Ribble Valley Borough Council  
Housing & Development Control

Application no: **3/2021/0952**

Address: **Root Farm Dunsop Bridge Clitheroe BB7 3BB**

Proposal: **Demolition and conversion of farm buildings to employment space (Use Class E) including demolition of agricultural building and new build workshop.**

Client <b>The Duchy of Lancaster</b>			
Contract <b>Root Farm Dunsop Bridge</b>			
Drawing title <b>PROPOSED SITE LAYOUT &amp; BLOCK PLAN</b>			
Scale <b>1:500</b>	Job No. <b>KL2887</b>	Dwg No. <b>04</b>	<b>B</b>

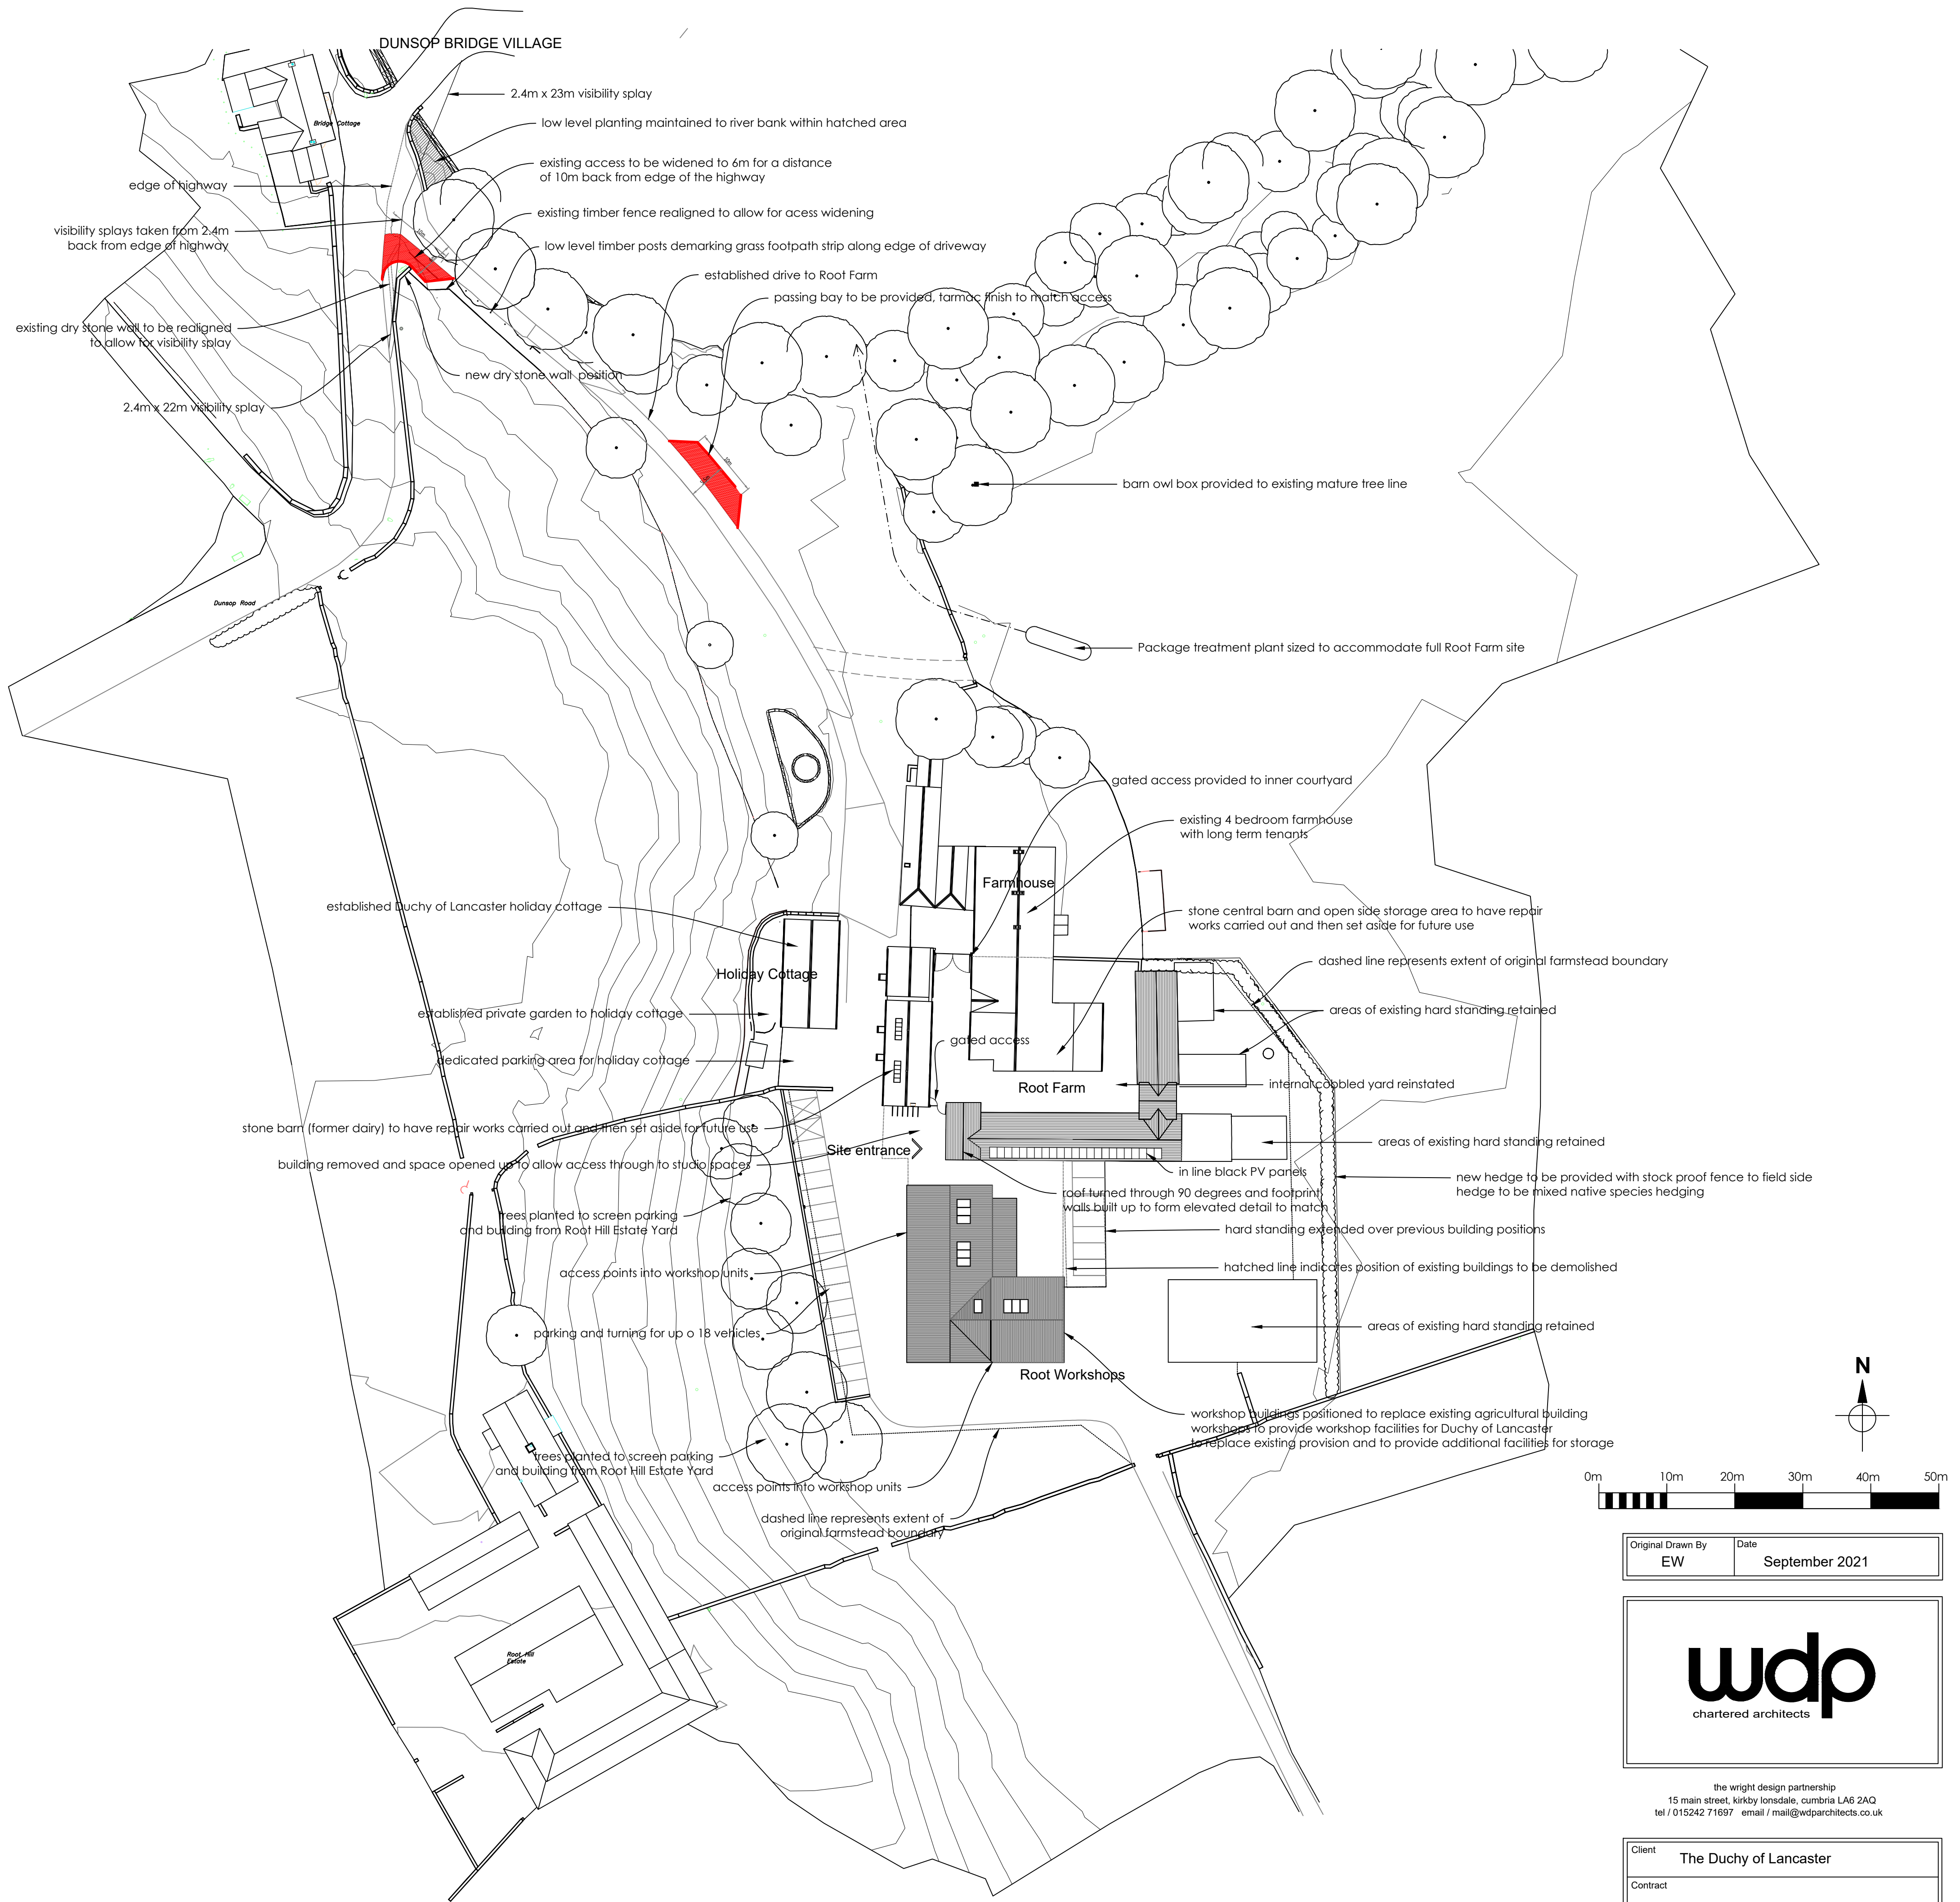
The LHA have reviewed WDP drawing number 04 Rev B titled "Proposed Site Plan and Block Plan" and are satisfied that the access arrangements complies with the LHAs guidance and so the LHA have no further comments to make regarding the access. The LHA do remind the Applicant that any access improvements at the site should be subject to a S278 agreement with the LHA.

It is also worth noting that the existing gully to the left of the access is likely to be relocated following the access improvements at the site. The LHA remind the Applicant that they will be liable to the full cost of relocating the gully further along Newton Road, but the works and the cost will be undertaken under the S278 agreement.

The speed survey found that the 85<sup>th</sup> percentile speeds for the 60mph road was 19.1mph to the right and 19.5mph to the left of the access. This means that the site is required to provide visibility splays of 2.4m x 23m to the right and 2.4m x 25m to the left of the access.

The LHA have reviewed WDP drawing number 04 Rev B titled "Proposed Site Plan and Block Plan" and understands that visibility splays of 2.4m x 22m to the left and 2.4m x 23m to the right have been provided at the site access. The visibility splay to the left of the access will be provided by offsetting the existing boundary wall, as shown on the drawing which the LHA have no objection to. However, while the visibility splay to the right complies with the LHAs guidance titled "Creating Civilised Streets," even by offsetting the boundary wall there is still a shortfall in visibility of 3m to the left of the access.

Notwithstanding this, the LHA will accept the shortfall in visibility to the left of the access with the shortfall being minimal.

The LHA also welcome the addition of a passing bay along the access track which is shown on WDP drawing number 04 Rev B titled "Proposed Site Plan and Block Plan." This will allow for two-way vehicle movements to occur at the same time along the track.

The LHA have reviewed WDP drawing number 04 Rev B titled "Proposed Site Plan and Block Plan," and understands that the site will provide 24 car parking spaces for the proposal.

While the LHA are unable to clarify whether the parking arrangements complies with the standards as defined in the Joint Lancashire Structure Plan with the site being classed as Use Class E, which overlaps multiple uses. The LHA are aware that should more car parking spaces be required there is an area classed as "hardstanding" on the drawing adjacent to the spaces. Therefore, more car parking spaces can be provided if required.

The drawing shows that the existing Public Footpath will be segregated from the access track by low level timber posts at the edge of the driveway. This will denote to pedestrians using the footpath to use the segregated grassed track rather than the main access which will be used for the proposal.

3. No part of the development hereby permitted shall be occupied until such time as the access arrangements shown on WDP drawing number 04 Rev B have been implemented in full.

7. The development hereby permitted shall not be occupied until such time as the parking and turning facilities have been implemented in accordance with WDP drawing number 04 Rev B. Thereafter the onsite parking provision shall be so maintained in perpetuity.
